**Jupiter Wind Farm - State Significant Development Application (SSD 6277)**

I refer to your email dated 29 November 2017 inviting the Division of Resources & Energy (DRE) to provide comments on the Jupiter Wind Farm - (SSD 6277) (the Project).

DRE has reviewed and assessed the adequacy of information in relation to the *Jupiter Wind Farm Environmental Impact Statement* dated October 2016 and provides the following advice:

**Figure 1: Jupiter Wind Farm proposal – Mineral Exploration Titles, Exploration Licence Applications and resources.**

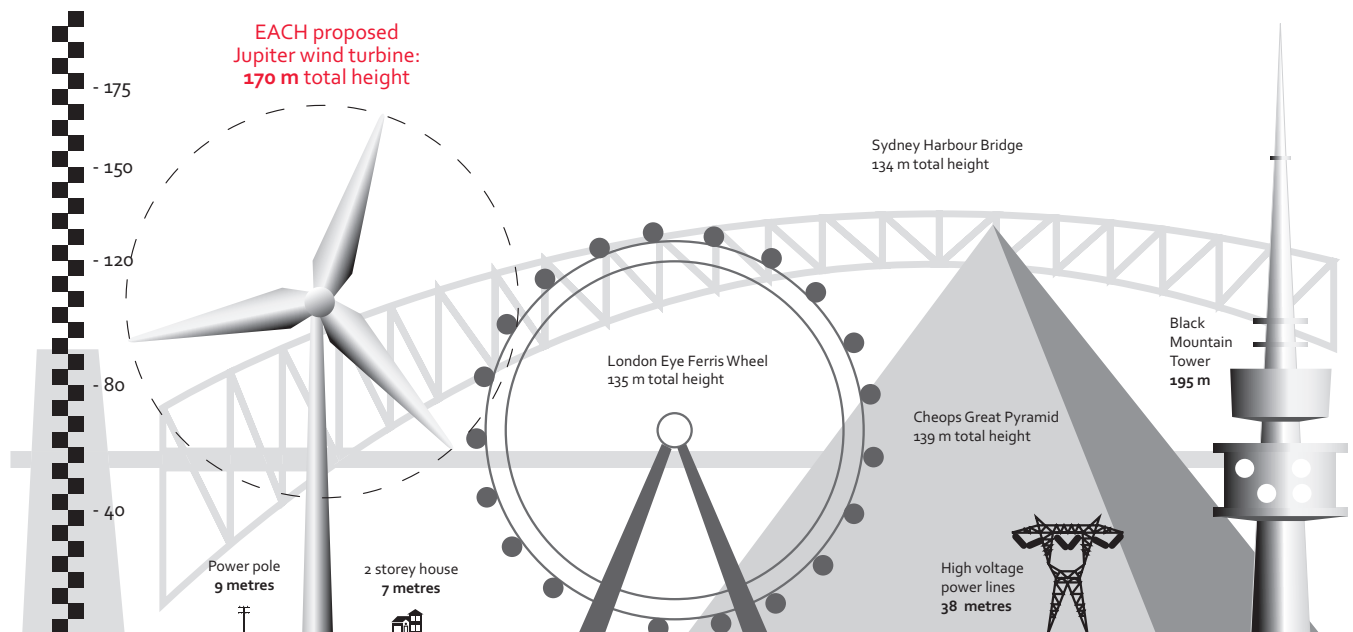
Construction of wind turbines in the northern precinct area will result in the sterilisation of the small deposits known as "Mt Boro Mine" and "Great Boro Mine" and has the potential to limit access to the area for future mineral exploration activity.

Based on upon a geological assessment of the area by DRE, the northern precinct (refer to Figure 1 attached) of the Project should be excluded from the development.
